**KIRKLEES METROPOLITAN COUNCIL
INVESTMENT & REGENERATION SERVICE**

DELEGATED DECISION TO DETERMINE PLANNING APPLICATIONS

Reference No: 2018/61/92842/E

Site Address: Former Combs Hostel, Hall Lane, Thornhill,
Dewsbury, WF12 0PL

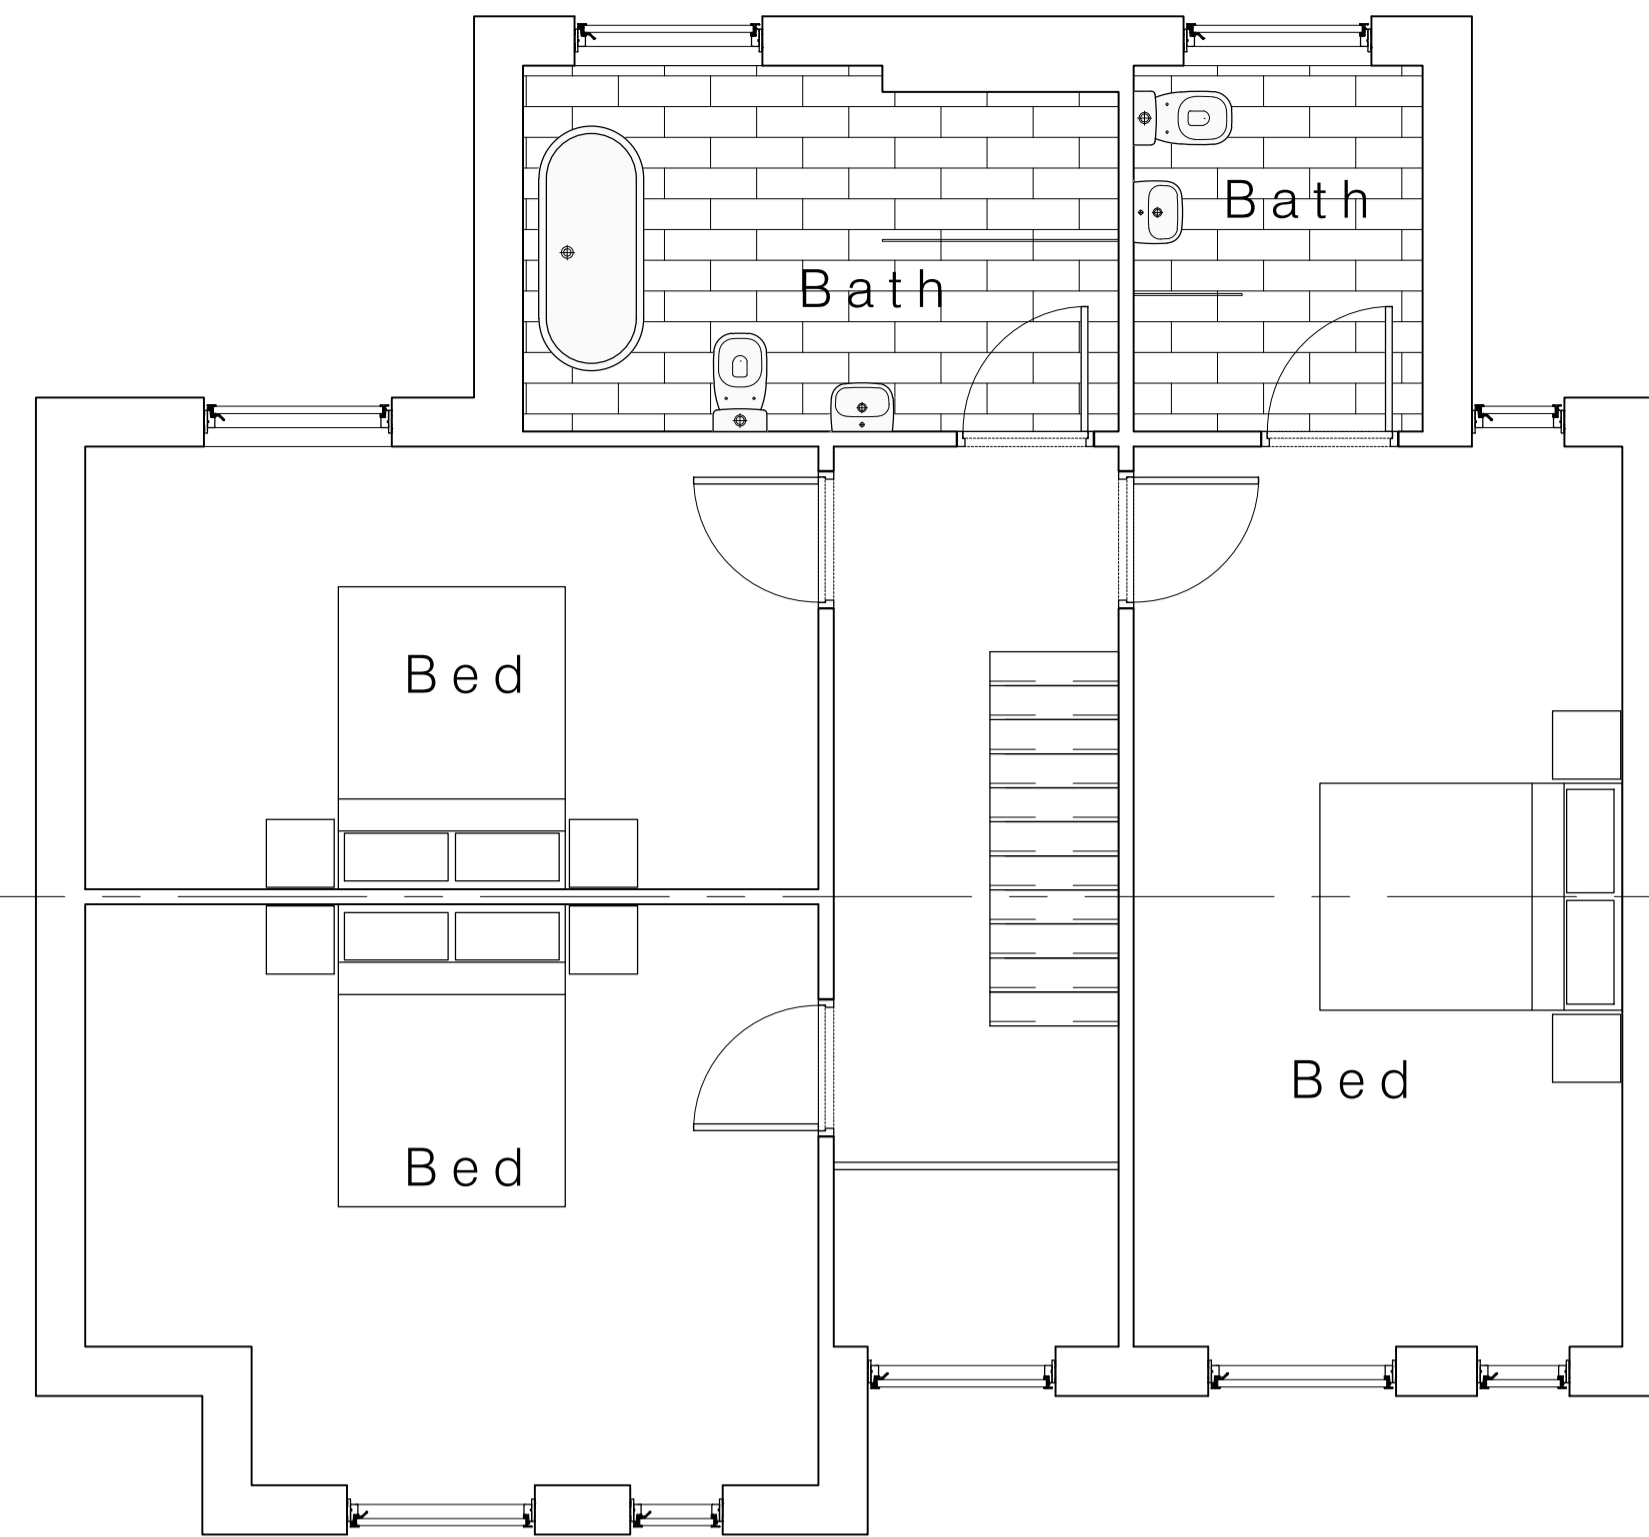
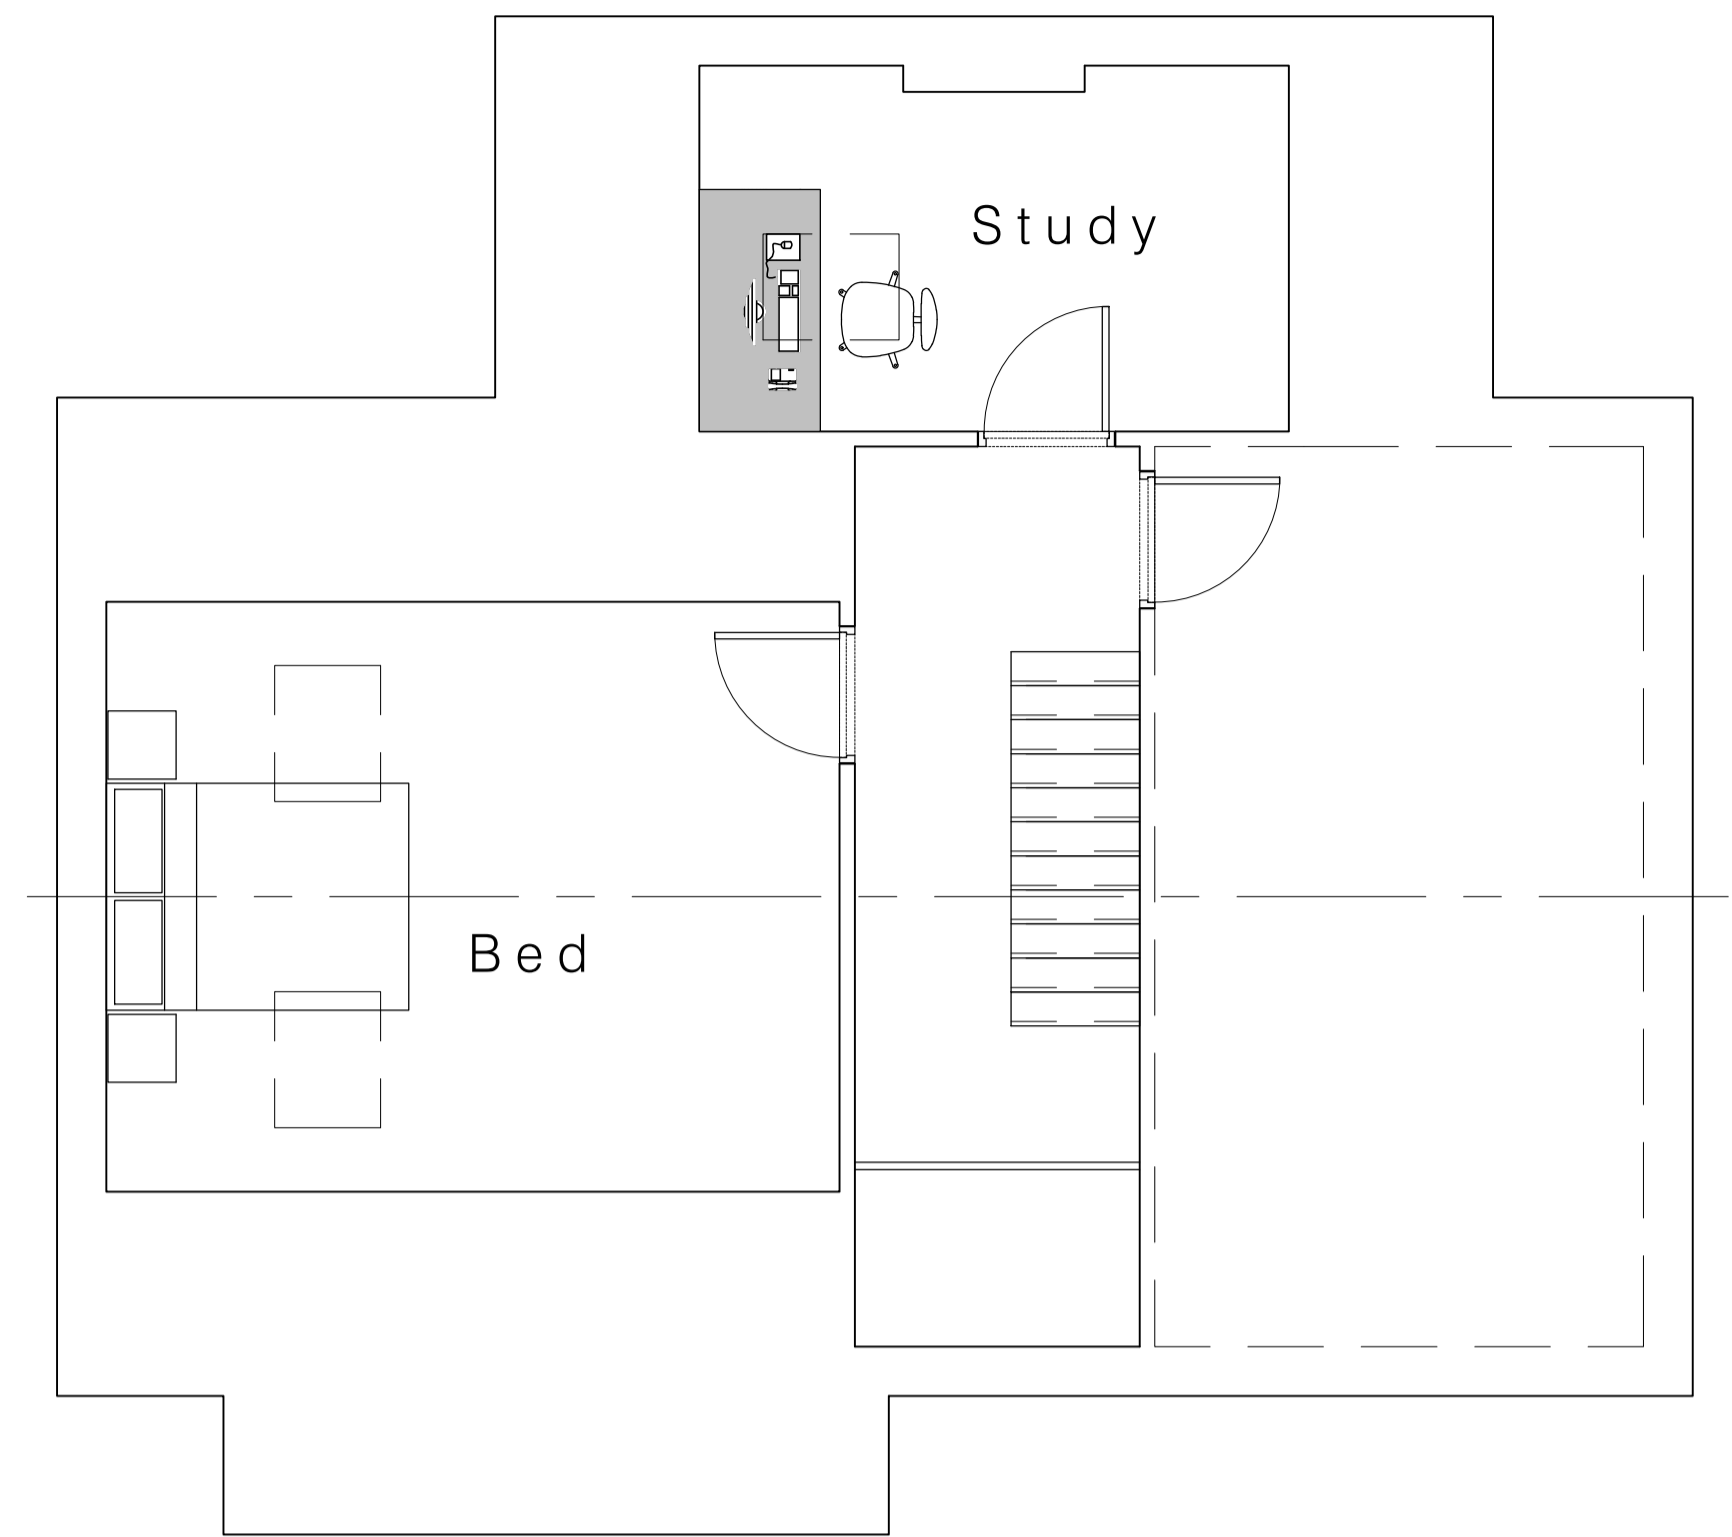
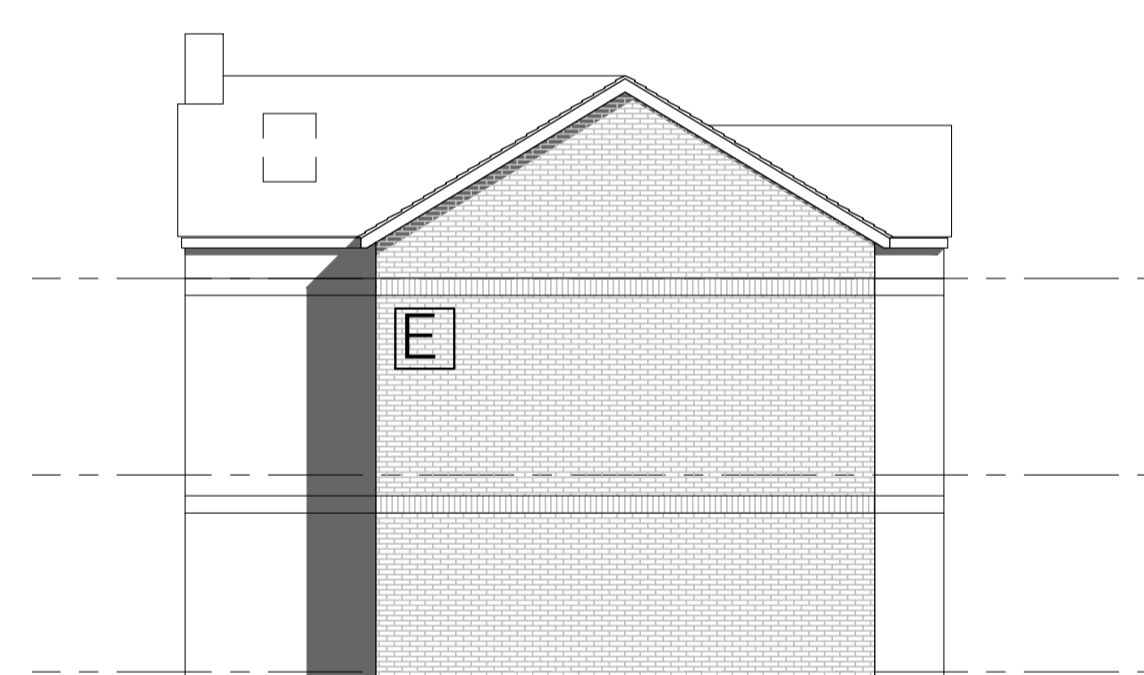
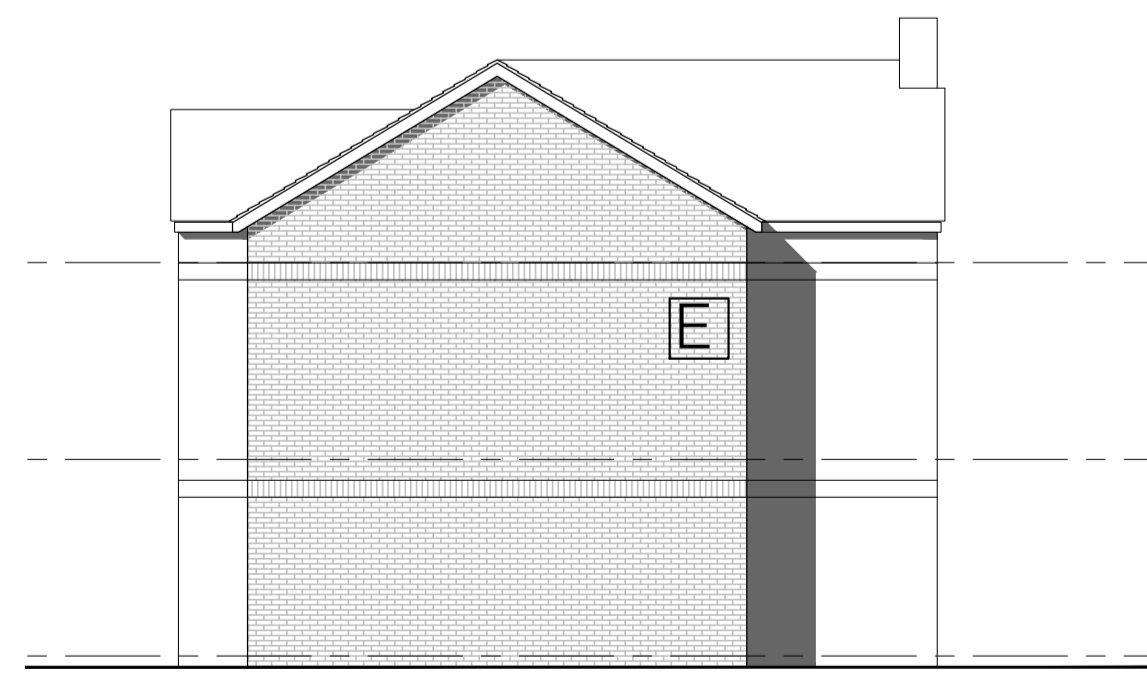
- The removal of dormer windows to the rear of plots 1-6 (house type A) to simplify the roof profile of these dwellings adjacent to the Conservation Area
- Inclusion of windows to the gable end plot 1 to break up the expanse of walling facing Hall Lane
- Changes to the fenestration of plots 19-22 (house type D) to give these dwellings a more consistent design theme
- Inclusion of windows in the gable end plot 22 to break up the expanse of walling facing Hall Lane

PROPOSED LAYOUT

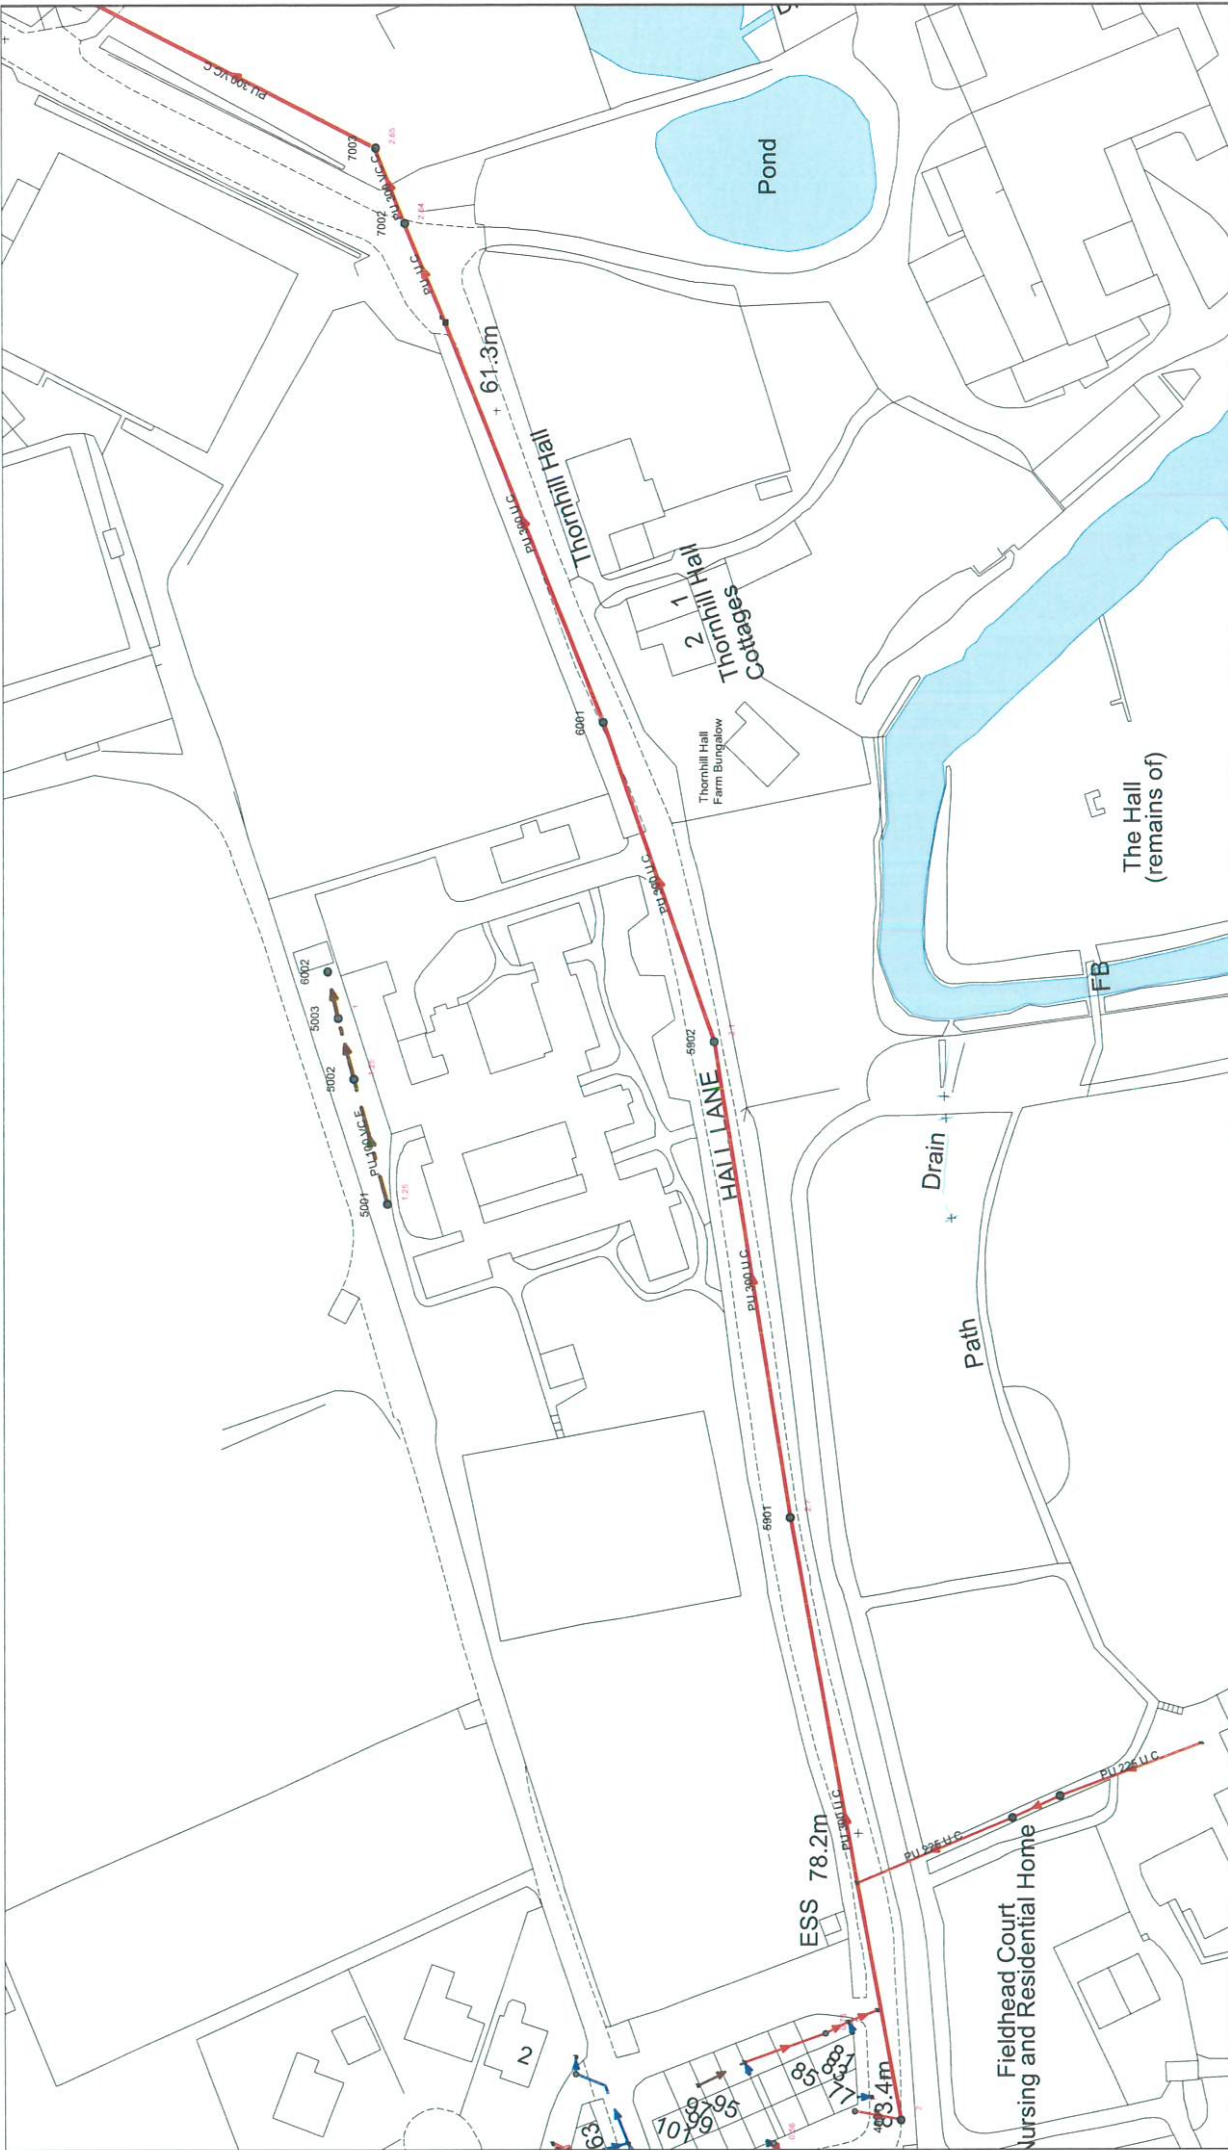
Summary of verbal comments 19/11/21: There are still concerns with some of the latest drainage information (submitted 29/10/21). The cellular storage tank is not considered appropriate (as per previous consultation response) and it is partly within private curtilage which causes maintenance concerns.

The drainage plans should not be approved under this Reserved Matters and a note should be added to the decision notice so that the applicant is made aware that the drainage scheme shown would not be considered acceptable when it comes to discharging the relevant drainage design conditions on the outline permission.

It is proposed to have a box culvert within the estate road; whilst this could be acceptable to the LLFA it may cause issues for road adoption because its size means it would be classed as structure.

The latest information appears to show that flood routing is acceptable subject to a condition requiring details of overland flows.
